**Written Representation
for the
Royal Society for the Protection of Birds
Comments on Deadline 6 submissions and actions from the
Examining Authority**

**Submitted for Deadline 7
10 August 2022**

**Application by Hornsea Project Four Limited for an Order
Granting Development Consent for the Hornsea Project Four Offshore Wind
Farm**

Planning Inspectorate Ref: EN010098

Figure 4: Onshore artificial nesting suitable land parcels – Whitby.

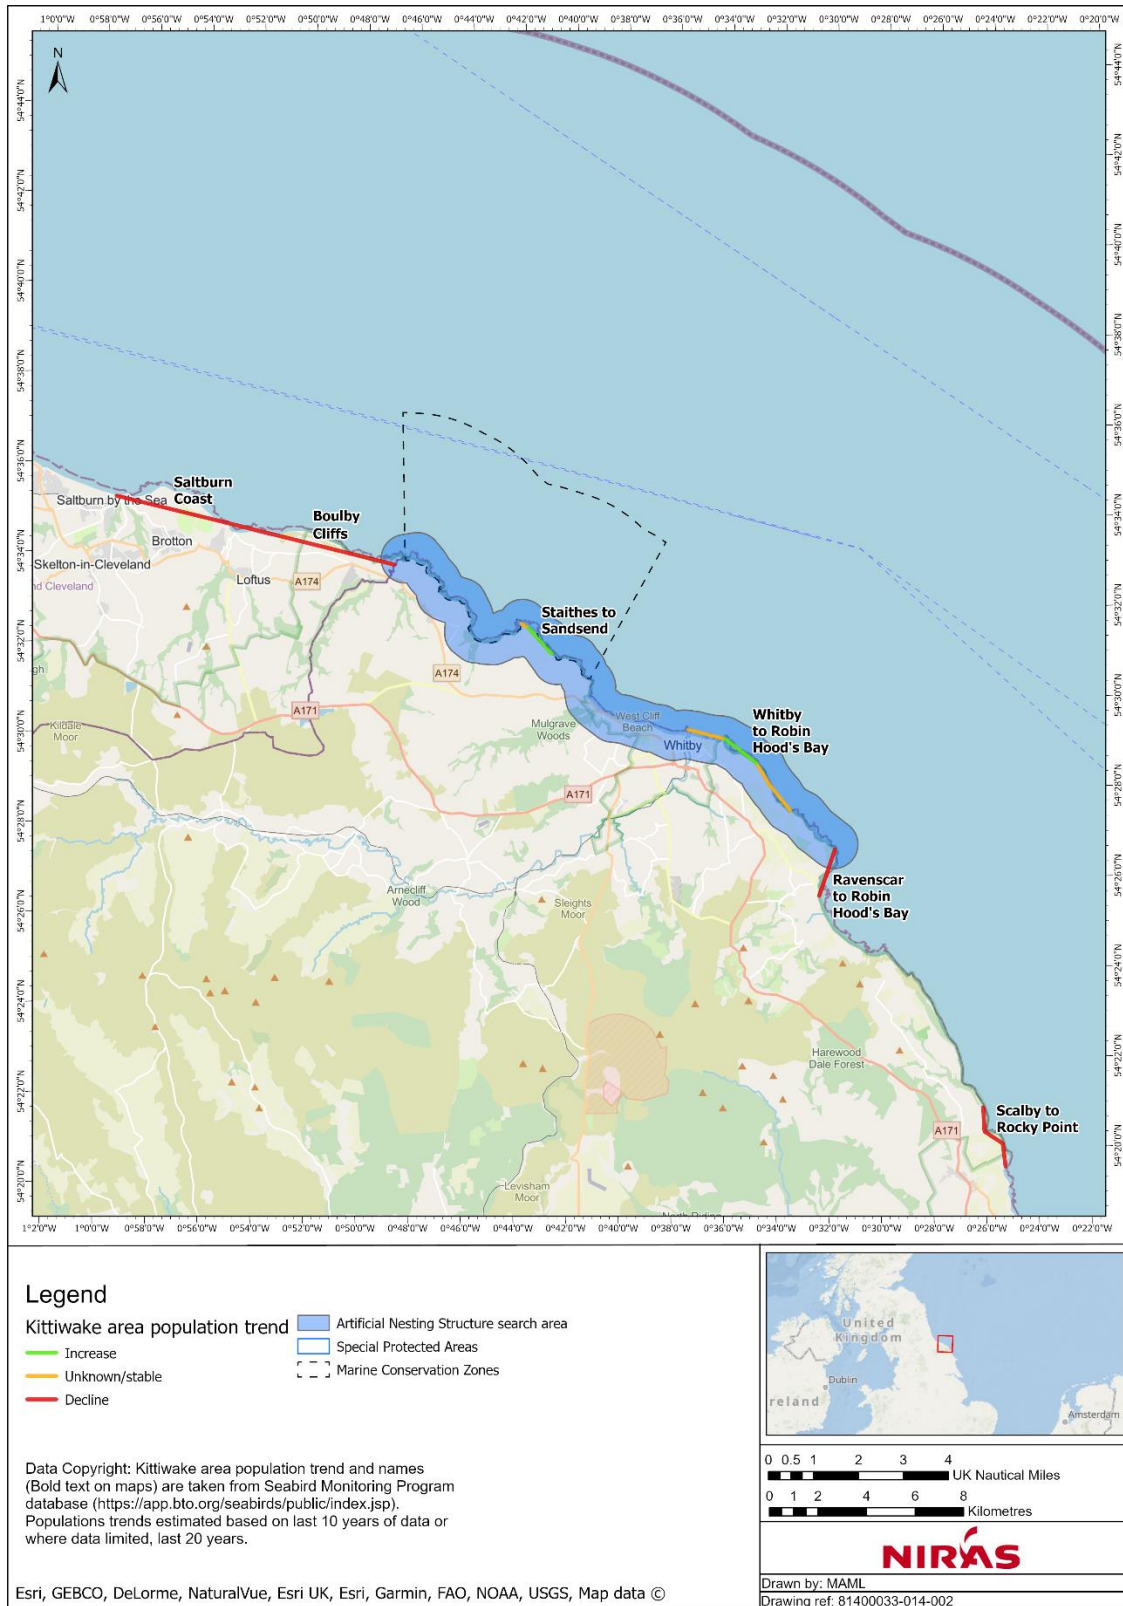
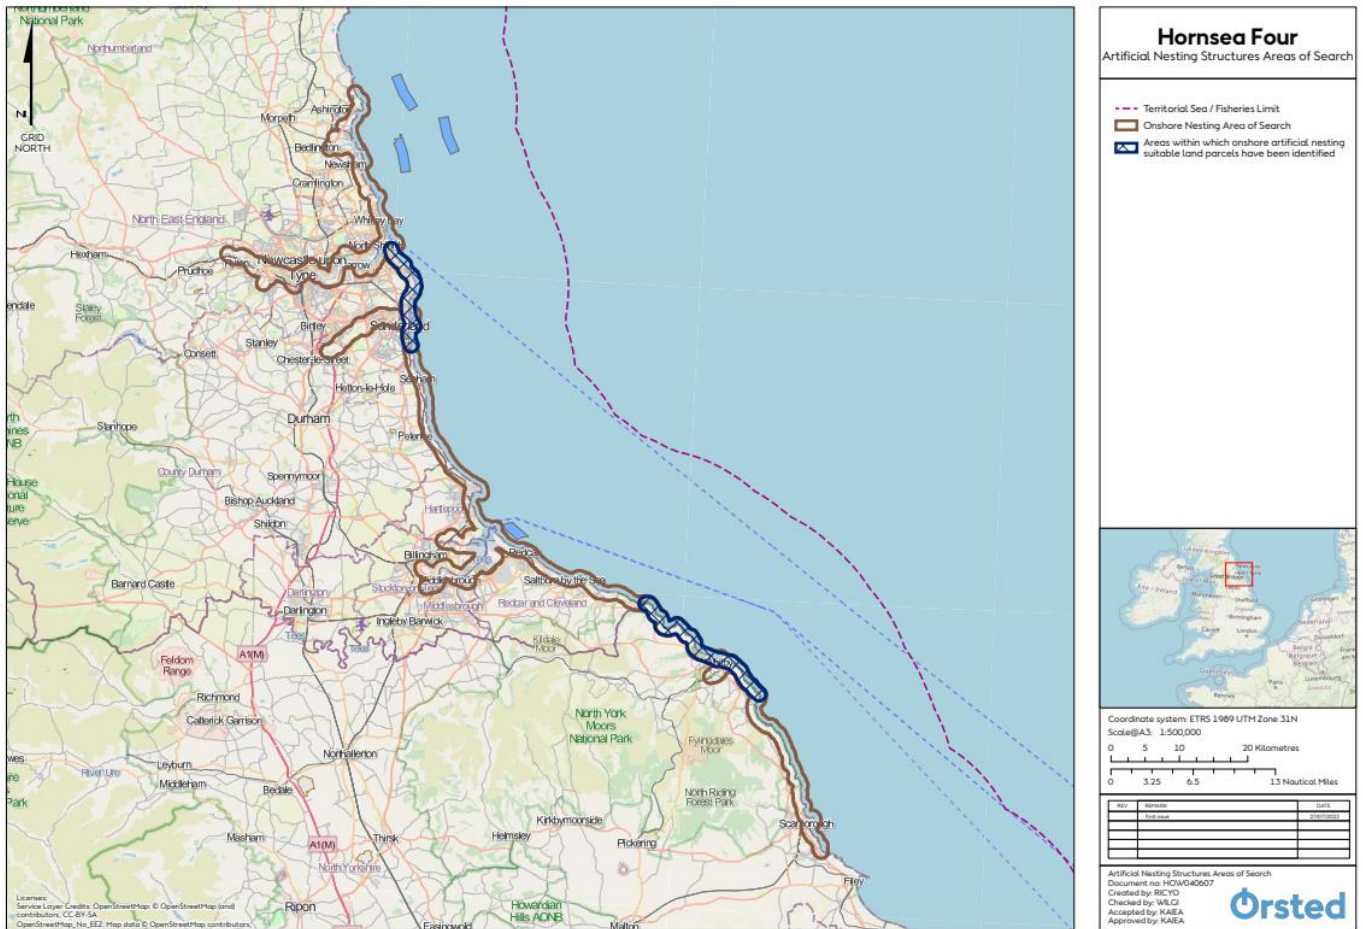
- 2.4. It states a total of 28 potential sites were identified and that seven sites with 152 land parcels were selected to progress to land acquisition stage. Just four suitable land parcels at two sites were taken forward for more detailed work. Of these four, the Applicant considered only one (Lythe, near Whitby) was a good case for an area with nesting space limitation. A second (Hawsker, south of Whitby) had suitable nesting habitat within 500m of the existing colony, making additionality difficult to prove. The remaining two land parcels were deemed unsuitable.

- 2.5. No site for an onshore kittiwake artificial nesting structure has yet been secured or relevant consents obtained.
- 2.6. This reinforces the RSPB's view (set out in REP2-089) that identifying and securing suitable sites from an ecological perspective is extremely challenging and cannot be relied upon.
